Application No: FG/157/21/PL
Site Address: 1 South Drive Ferring BN12 5QS
Description of works: Demolition of existing single dwelling & construction of new single dwelling. This site is in CIL Zone 4 & is CIL Liable as new dwelling.

Thank you for your internet representation made on 6th October 2021 which has been recorded as an objection with the comments as follows:

PLANNING
 1 South Drive, Ferring
 First and Second Floor Plan as Proposed
 21003
 Scale 1:100 SK12 Rev. D

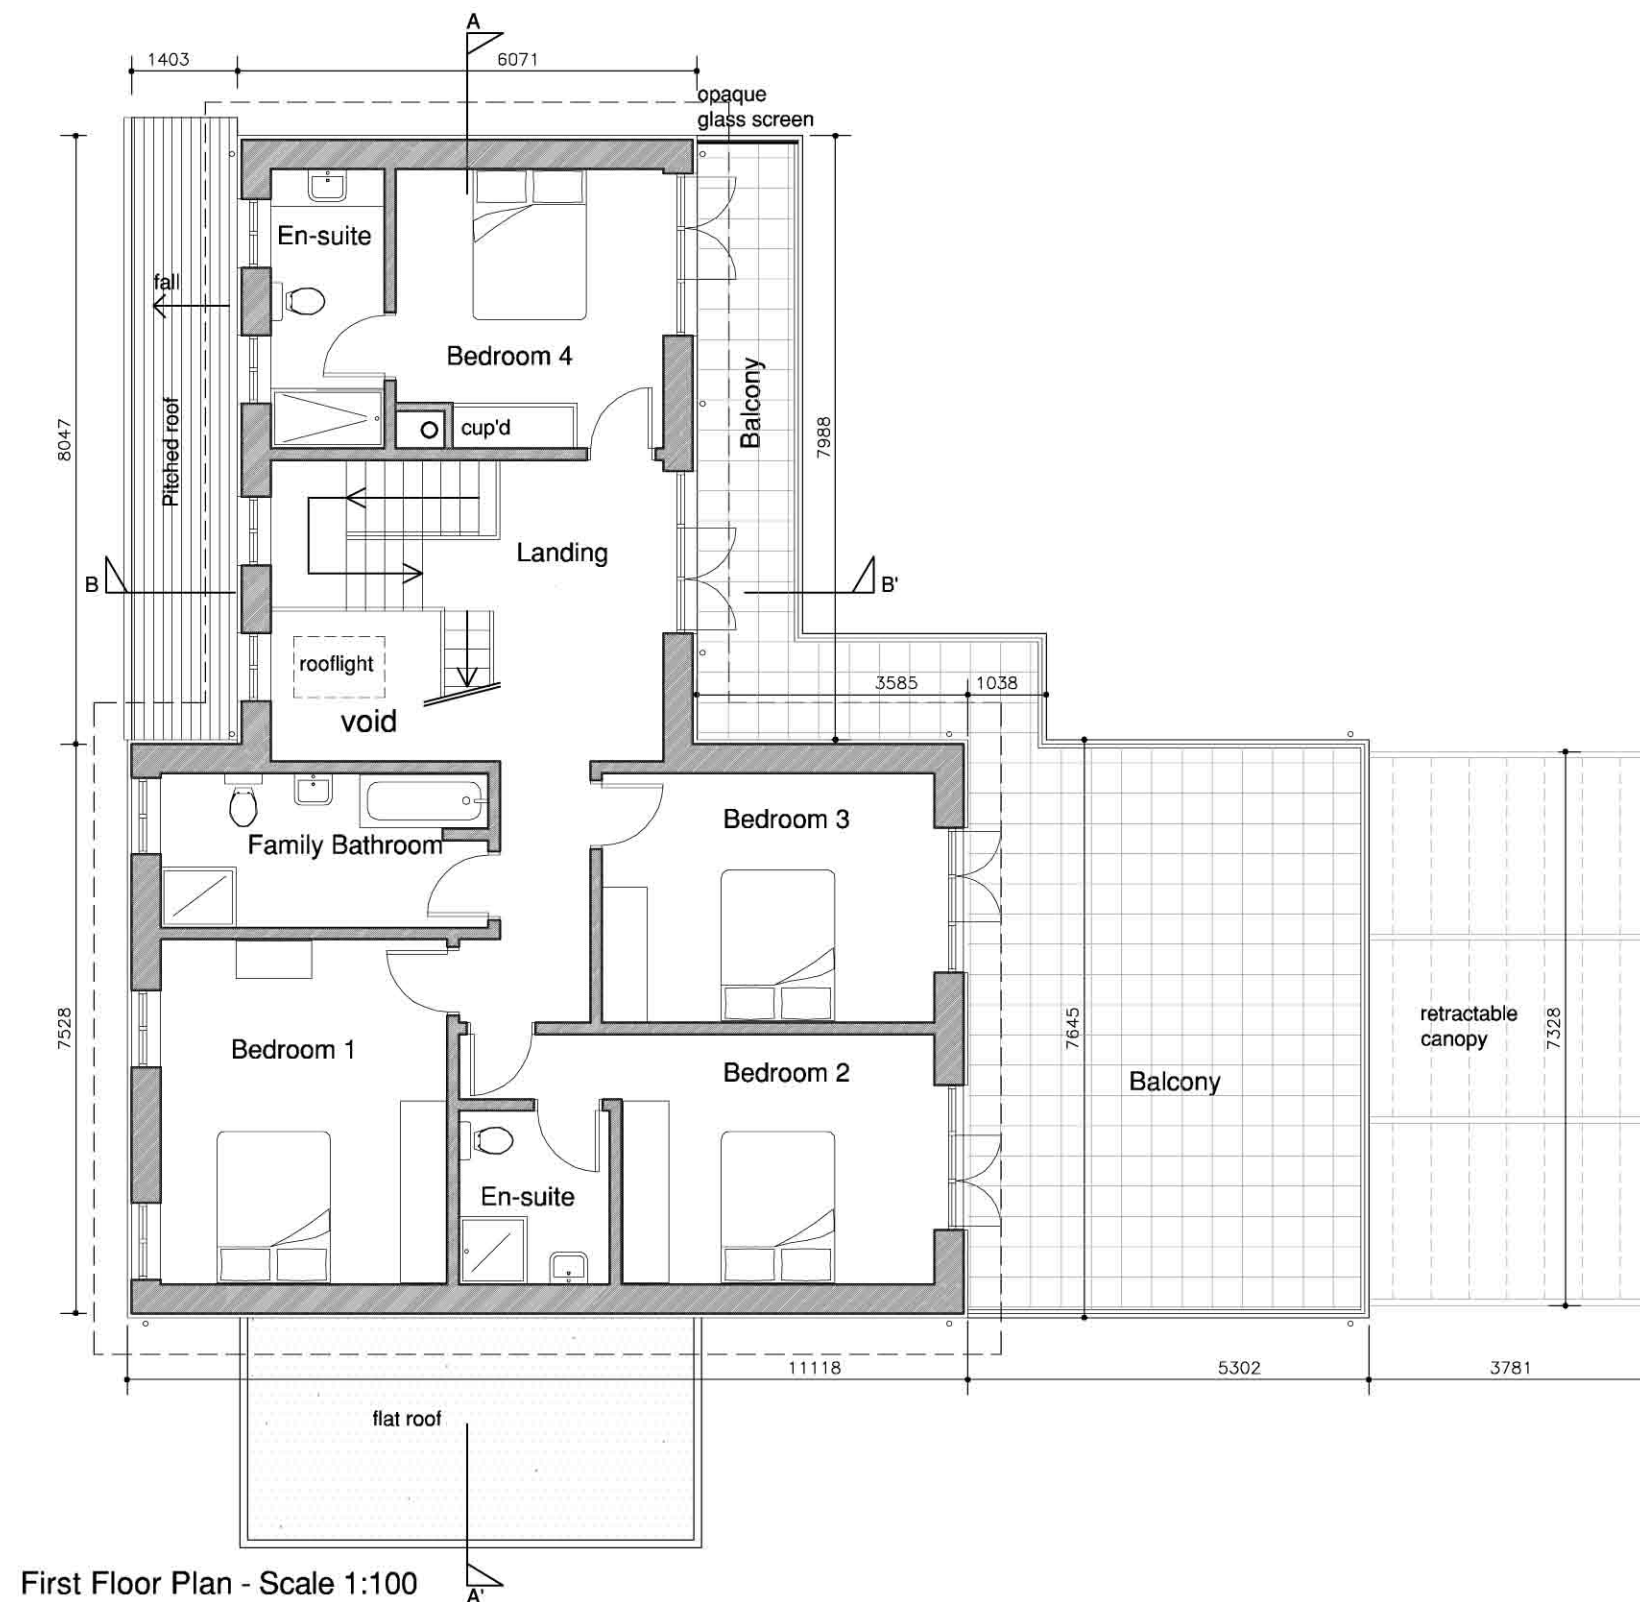
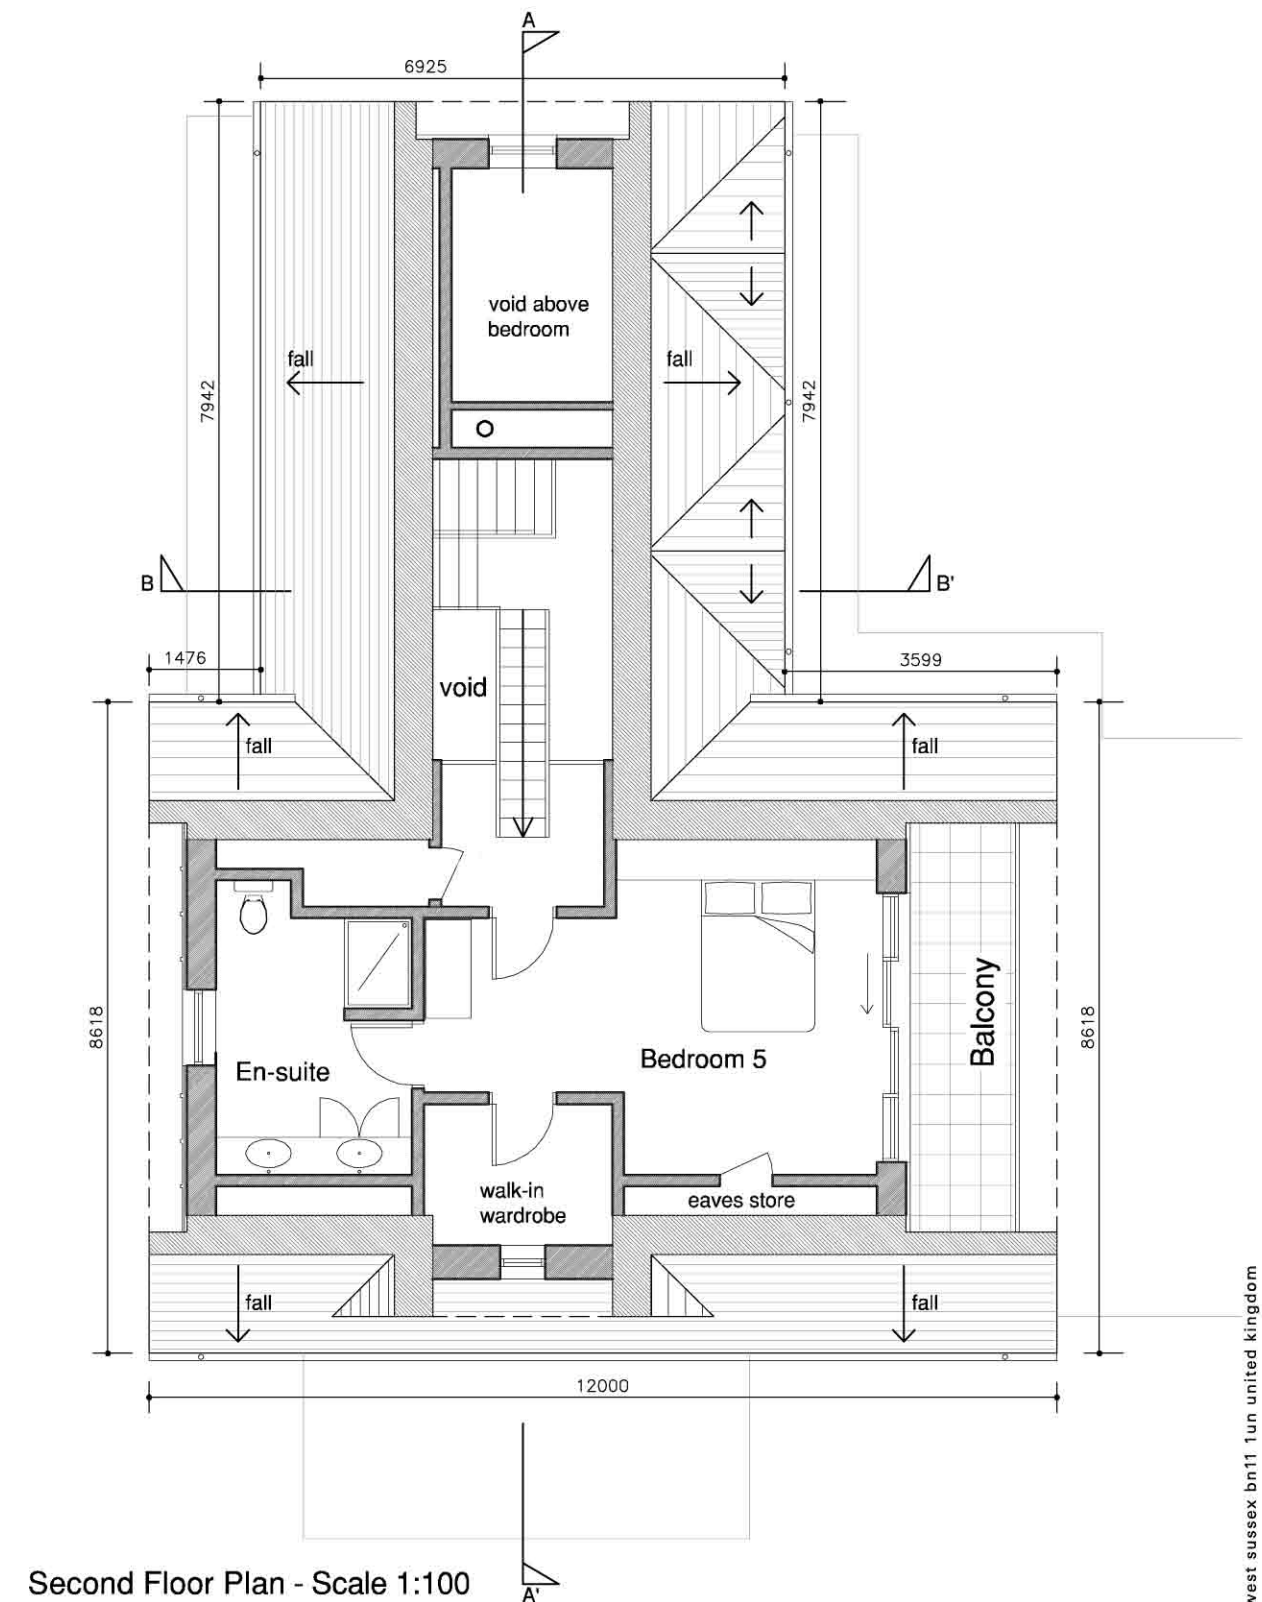
The second floor windows would impact on the visual harmony of the neighbouring properties. While neighbouring properties also back onto Patterson's Walk, privacy of their gardens can currently be achieved through landscape design and planting. This development would create high level overlooking of the gardens in such a way as to deprive adjacent properties of that privacy and seclusion.

PLANNING
1 South Drive, Ferring
Existing Footprint and Outline
21003
Scale as shown @A3
SK28

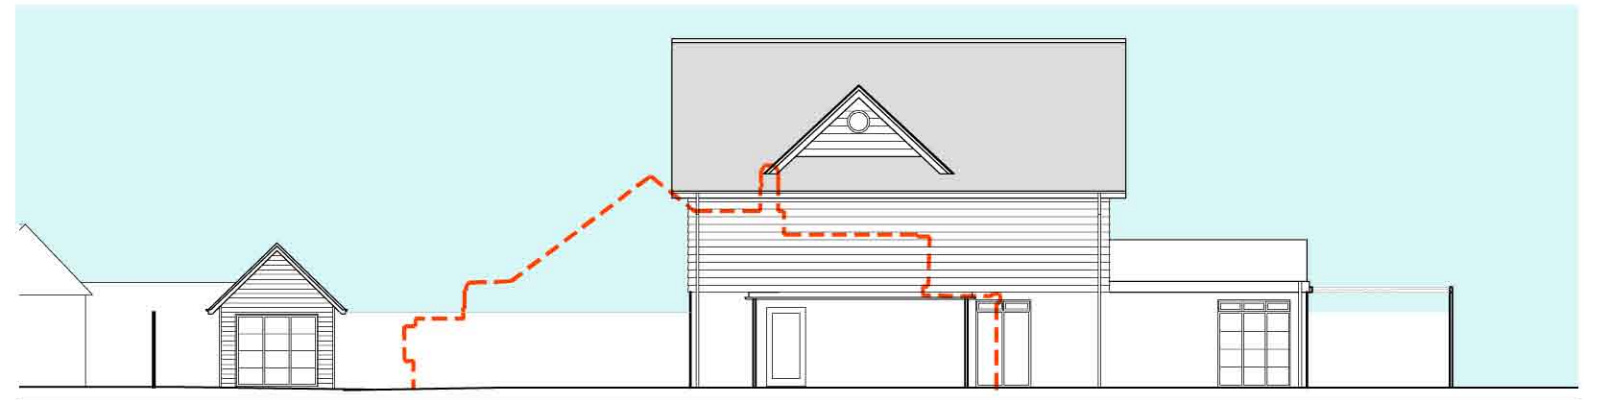
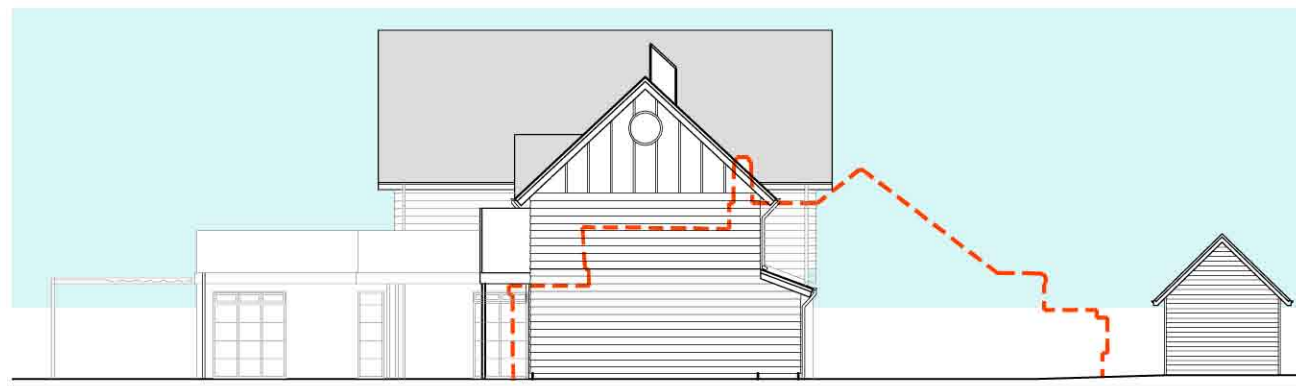
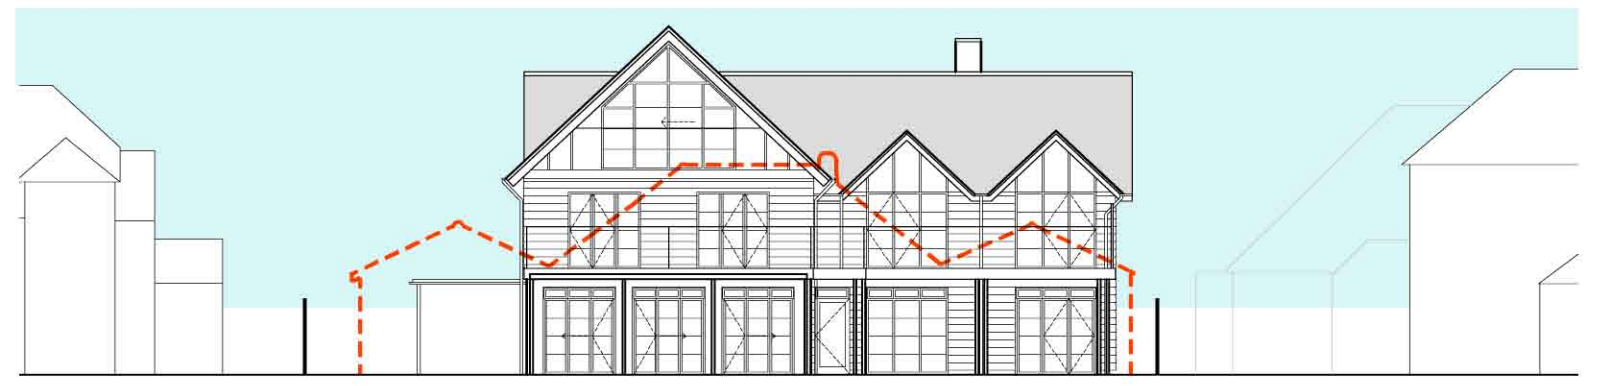
This proposed re-development is out of keeping with the adjacent properties and fails to respect the style and character of its immediate neighbours. The design features are significant in that the high-level mass of the 2nd floor on the southern aspect would be overly dominating as seen from Patterson's Walk and the beach. Patterson's Walk which borders the southern boundary is a well-used local attraction offering residents and visitors a level access to enjoy the seafront in a traditional setting. Such dominant high level developments would not be in keeping.

The increased height and mass in the redevelopment from a bungalow to three storey property would overly dominate and overshadow the more traditional dwellings, particularly that on the northern side which would be overshadowed.
